CITY OF ALBUQUERQUE

RE: **Winrock Road Town Center**
2100 Louisiana Blvd NE
Drainage Master Plan- Drainage Implementation Plan
Engineer's Stamp Date: 5/16/19
Hydrology File: J19D058

Based on submittal received on 5/17/19, the Drainage Implementation Plan cannot be approved for Site Plan for Building Permit until the following are corrected:

STORM DRAIN AP-D 100

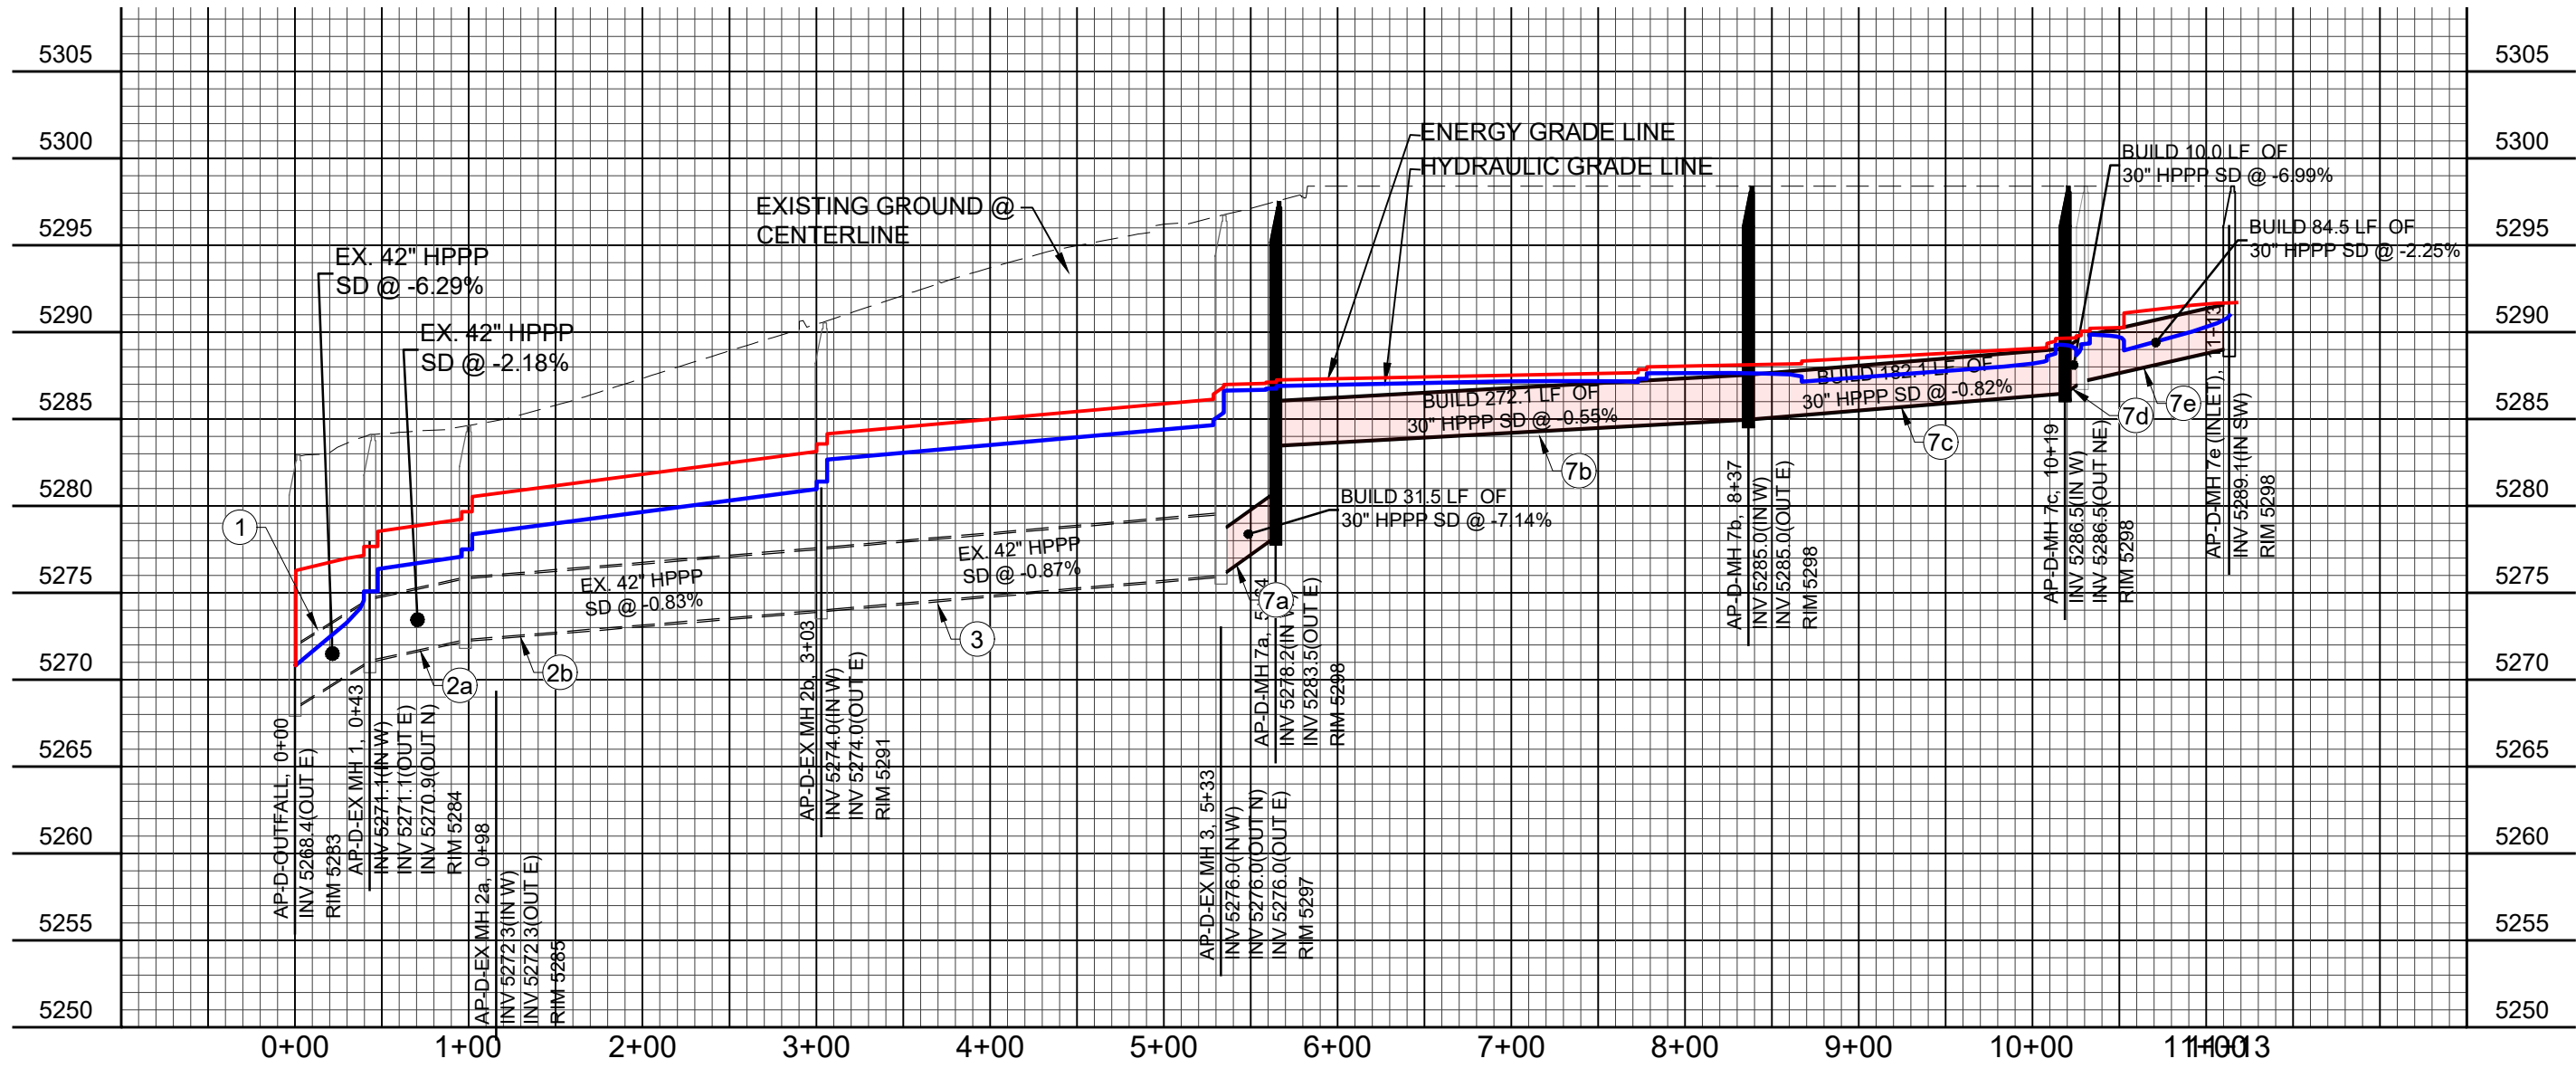
- ii. pipe 6 Q is shown as 24cfs on the table, but is shown as 51cfs on the exhibit 1 table.
 - e. On Exhibit 5, pipe 7a-7e are called out as 30" in profile, but are 24" in the table and 42-30" on the exhibit 1 table

WINROCK TOWN CENTER			
PHASE B INFRASTRUCTURE IMPROVEMENTS			
TITLE: STORM DRAIN AP-D 300			
Design Review Committee	City Engineer	Ms./Day/Yr.	
		Last Update	
City Project No.	Zone Map No.	Sheet	Of
4553.90	J-19-Z		EXHIBIT 6

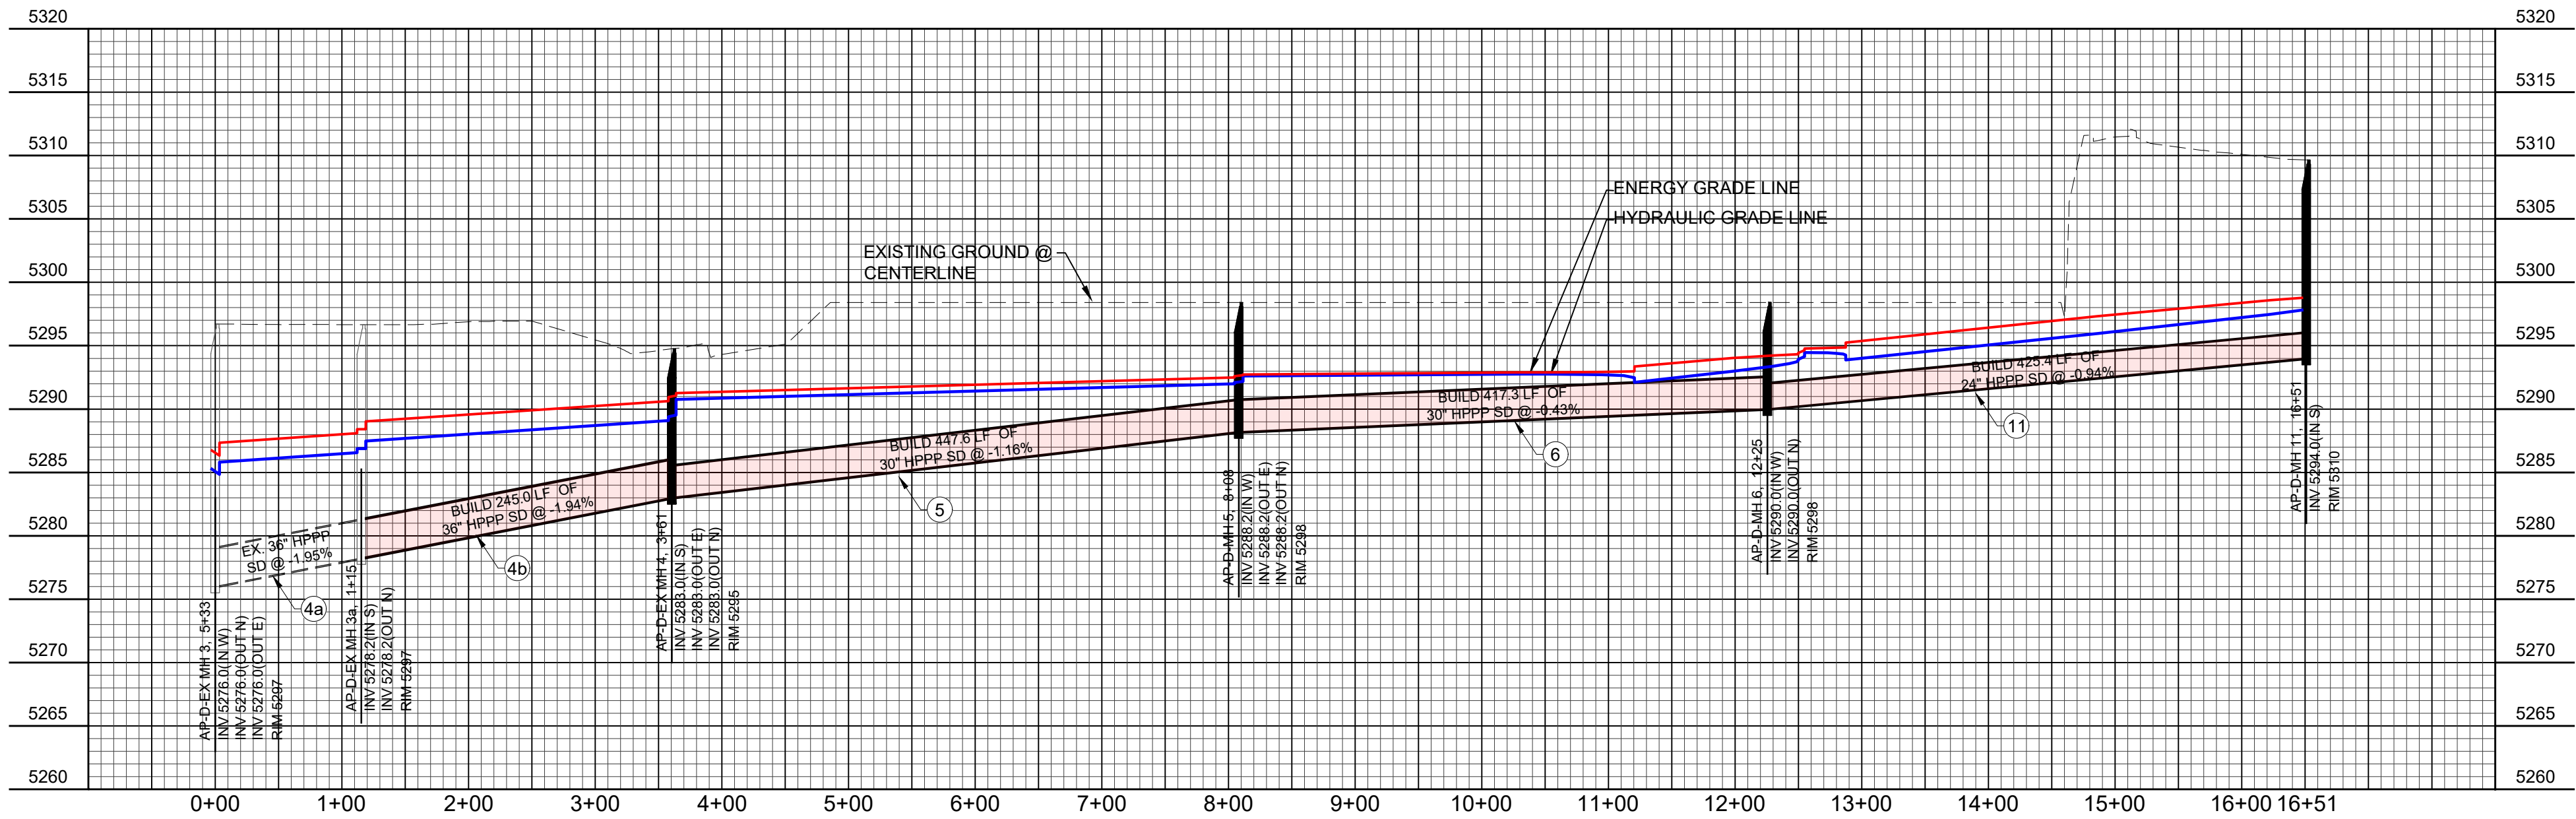
- f. On Exhibit 6, pipe 6 is called out as 30" in profile and 30" on the exhibit 1 table, but is 24" in the table.
 - g. On Exhibit 7, pipe 8 is called out as 30" in profile, but is 36" in the table and 36" on the exhibit 1 table

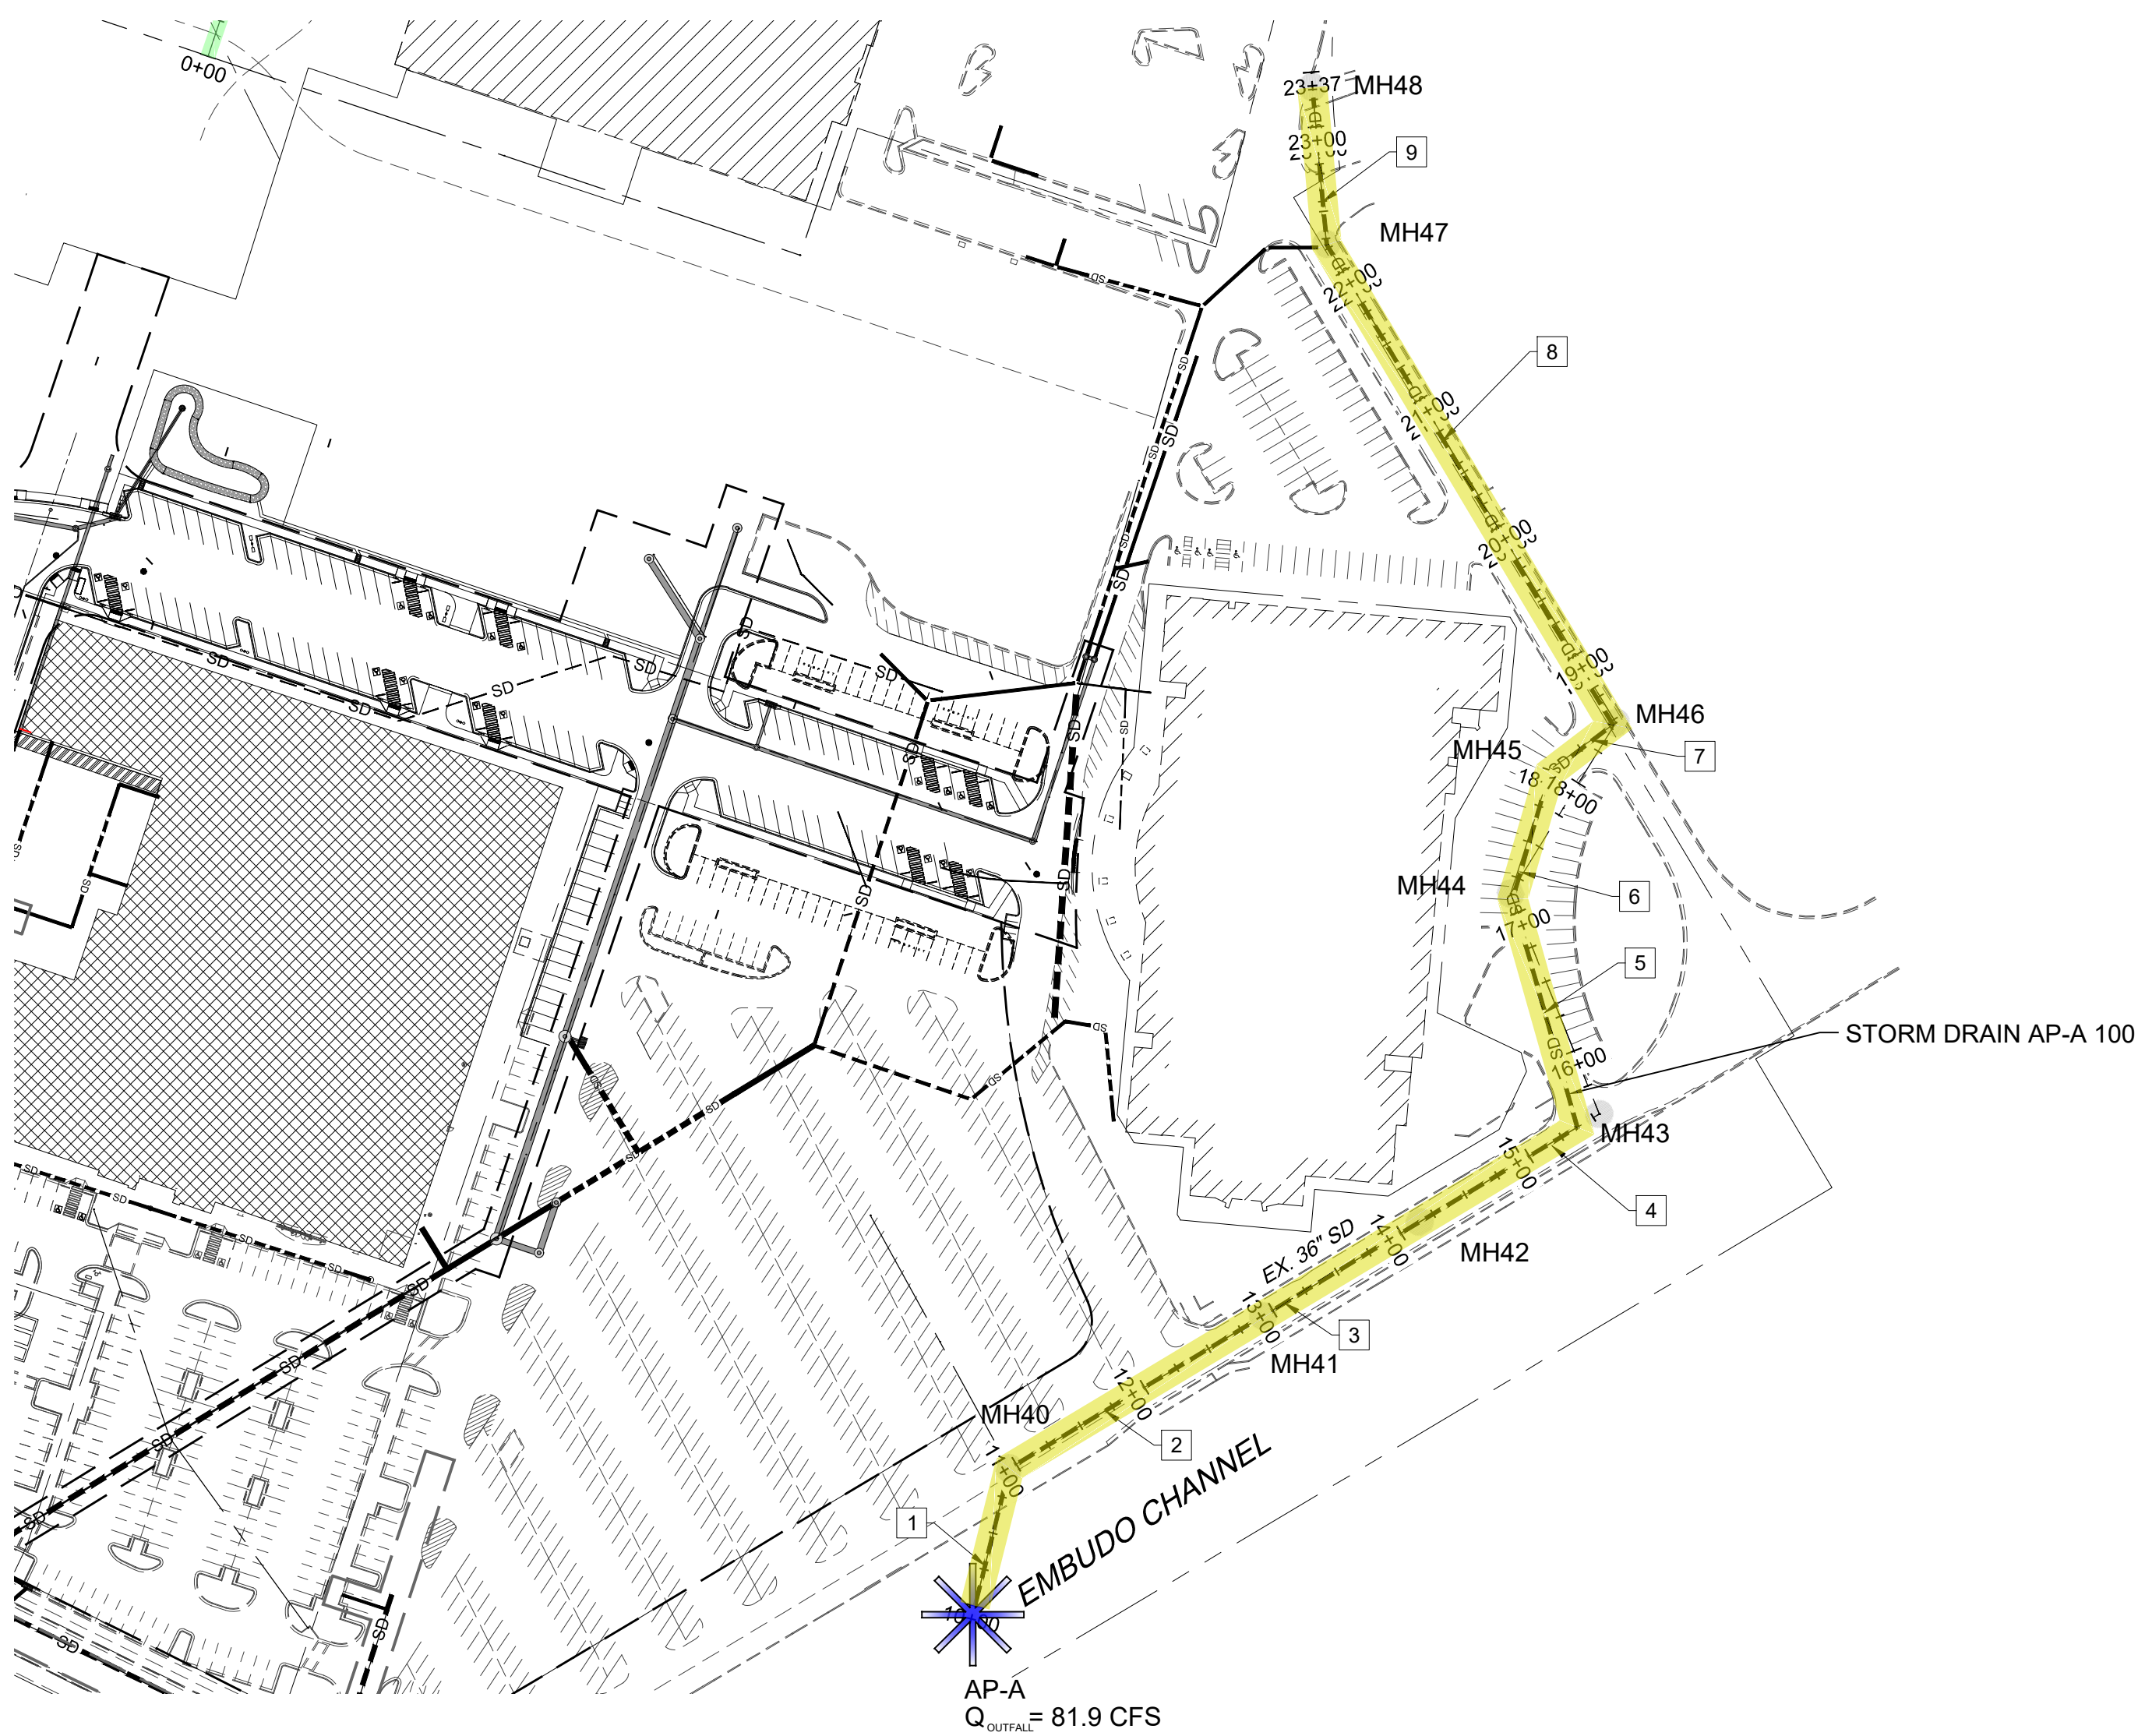
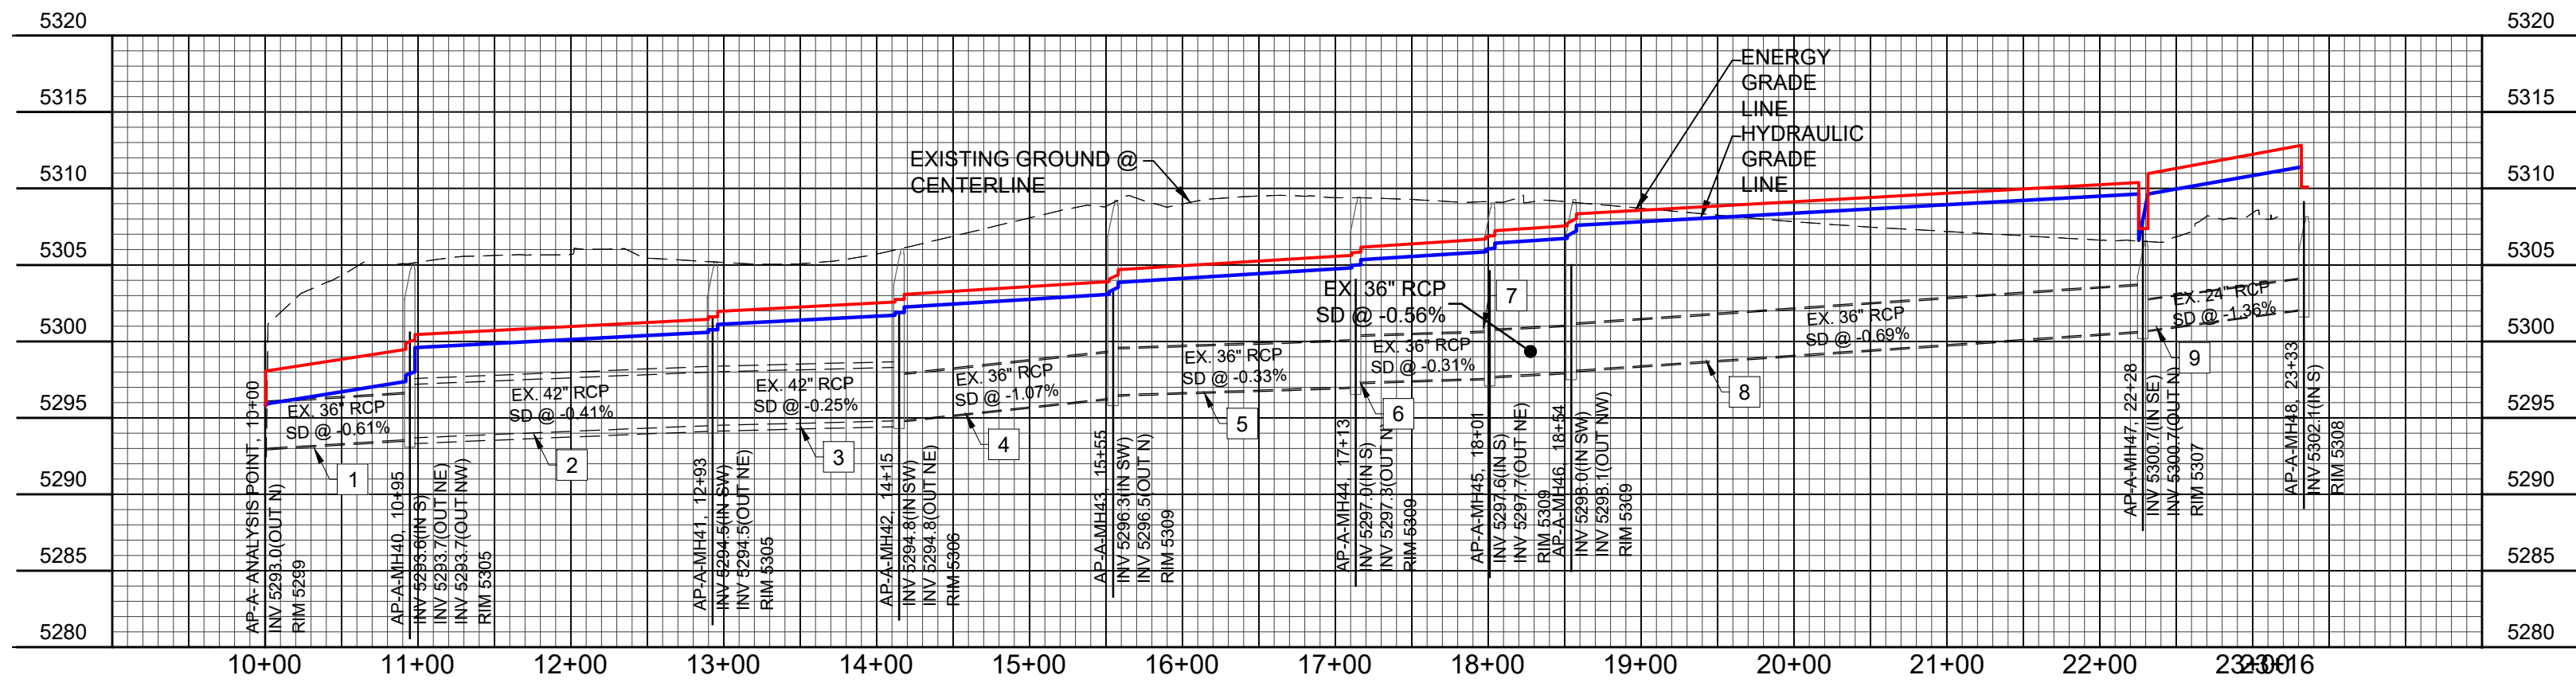
- h. On Exhibit 8, the table and profile and table on Exhibit 1 don't match:
 - i. pipe sizes are inconsistent between the table and profile and the exhibit 1 table;

- ii. pipe type is shown as HPPP (isn't it RCP here?);
 - iii. manhole labels in the table are inconstant with the profile and exhibit 1 profile
